RE: RESPONSE TO SUBMISSIONS (SSD 7317, MOD 19 – PRECINCT MARKER SIGNAGE)

Ethos Urban has prepared this letter on behalf of Mirvac Projects Pty Ltd (Mircac) to support the response to the Department's request for a Response to Submissions (RTS), dated 21 July 2020. The request for an RTS relates to the Modification Application (MOD 19) to amend State Significant Development (SSD) Consent SSD 7317, which relates to the Australian Technology Park, South Eveleigh.

Central Avenue – Location 2

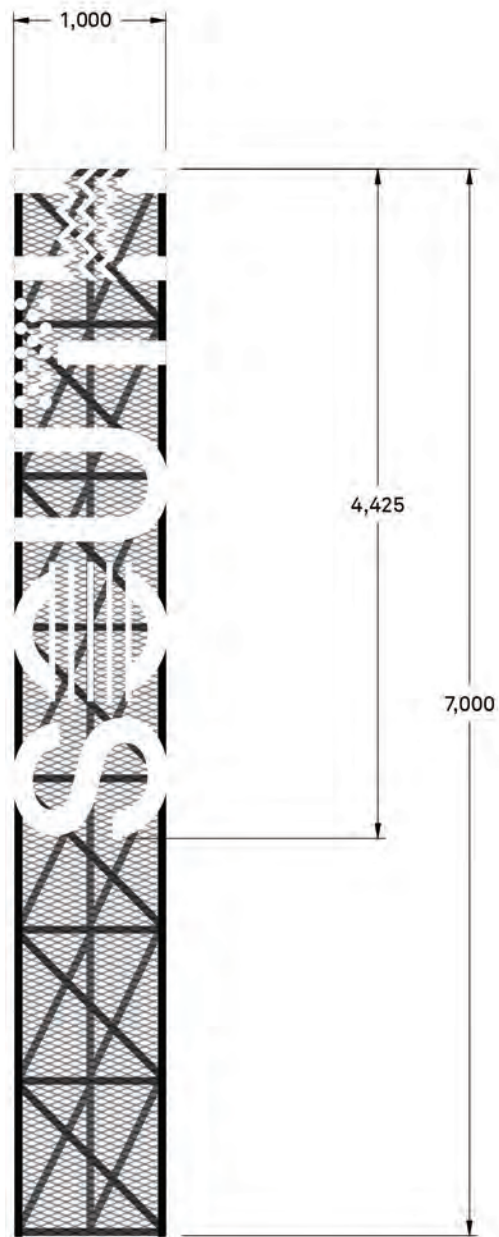
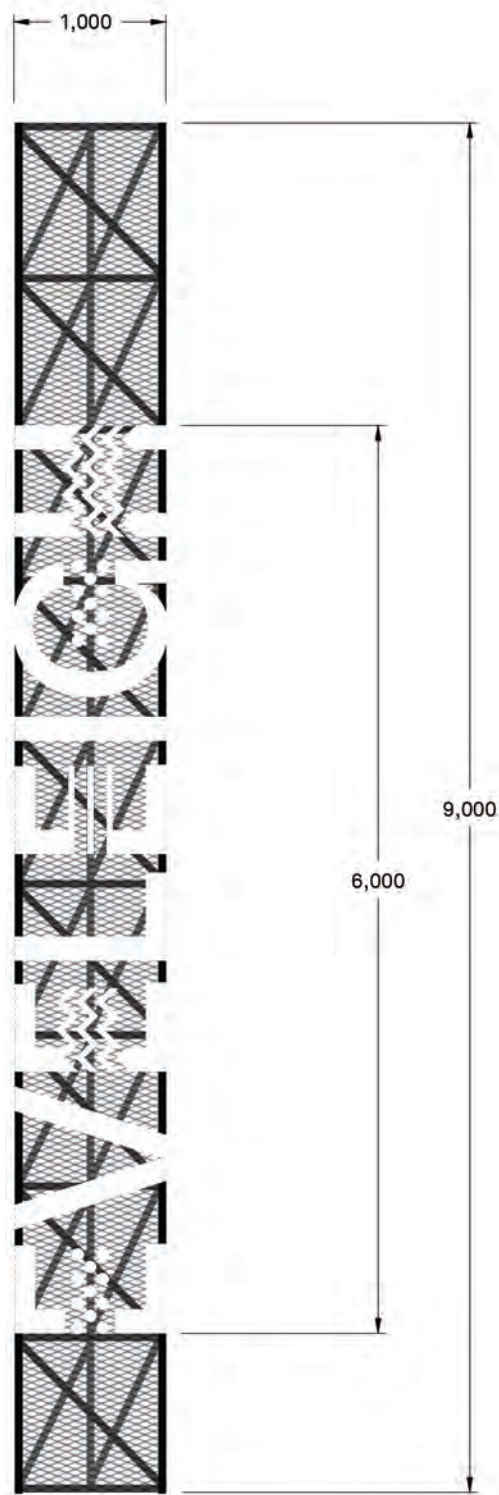
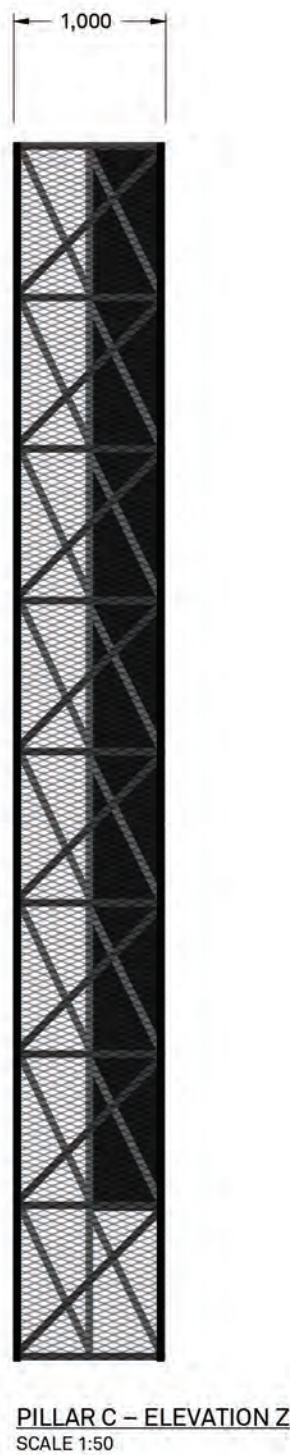
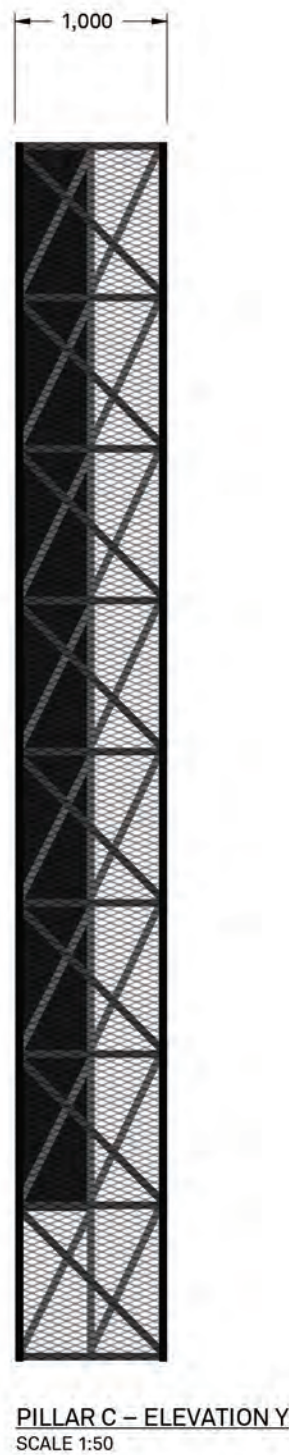
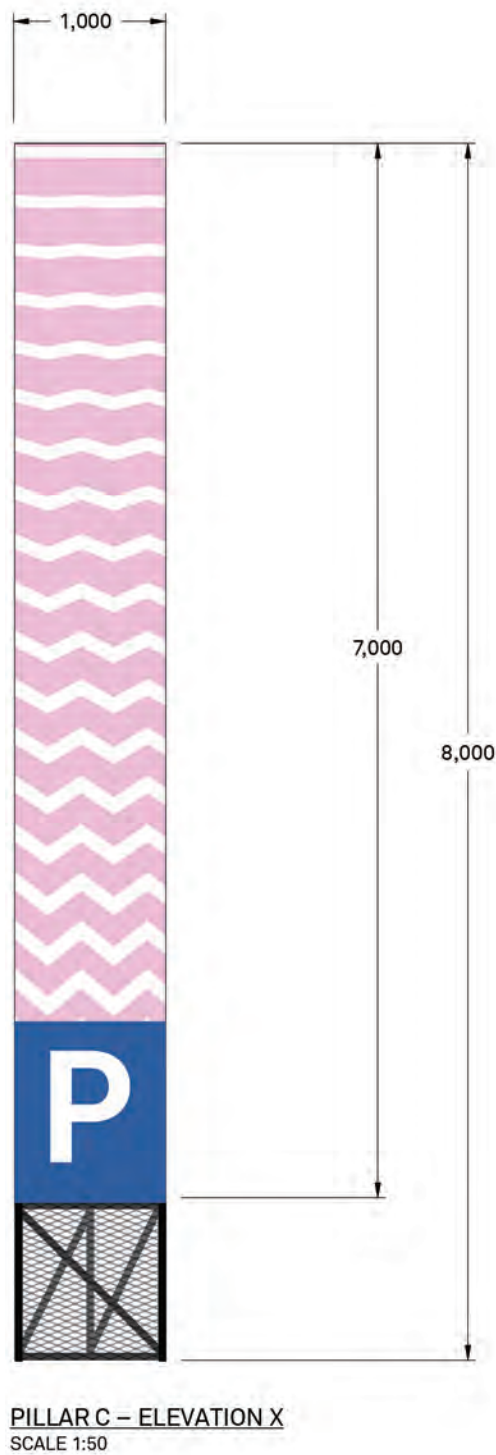
Submission	Comment
City of Sydney Council	
<i>The entire ATP site is identified as a heritage item of State significance under the Heritage Act 1977. The size, scale and illumination of the signs must be compatible with the heritage context, as deemed appropriate by Heritage NSW.</i>	As noted in the comments re-iterated below, the NSW Heritage Division considers that the proposed signs are considered to be acceptable.
<i>The Proposal involves the illumination of the signs between 6.00am to 1.00am to align with the hours of operation of food and drink offerings within the precinct for the purposes of wayfinding and precinct identification. The illumination of the signs must not detract from the amenity of neighbouring residents or reduce the safety for roads, pedestrians and bicyclists. Consideration should be made to restrict the hours and impose a curfew for illumination of the signs.</i>	The proposed hours of illumination of each of the signs is set out in Table 2 of this report. Amendments to the proposed hours have been made in consideration to the issues raised in the consultation exercise with residents of The Watertower apartments on Cornwallis Street and the Zinc apartments on Garden Street. In consideration that the lightspill assessments that were originally submitted with the application confirmed that the proposed signs comply with all relevant requirements of AS 4282-2019 Control of Obtrusive Effects of Outdoor Lighting and the Sydney Development Control plan (Signs and Advertisements) 2012, it is considered that the revised signage designs and revised illumination hours will also not give rise to any unacceptable lightspill impacts, glare or safety issues and will not detract from the amenity of neighbouring residents or accommodation. The internal illumination of the light poles of the Central Avenue sign at Location 2 have been removed from the proposed design and this demonstrated in the drawings included at Attachment A.

The proposed plans for the Central Avenue sign included at **Attachment A** demonstrates that the LED cross members within the sign have been removed.
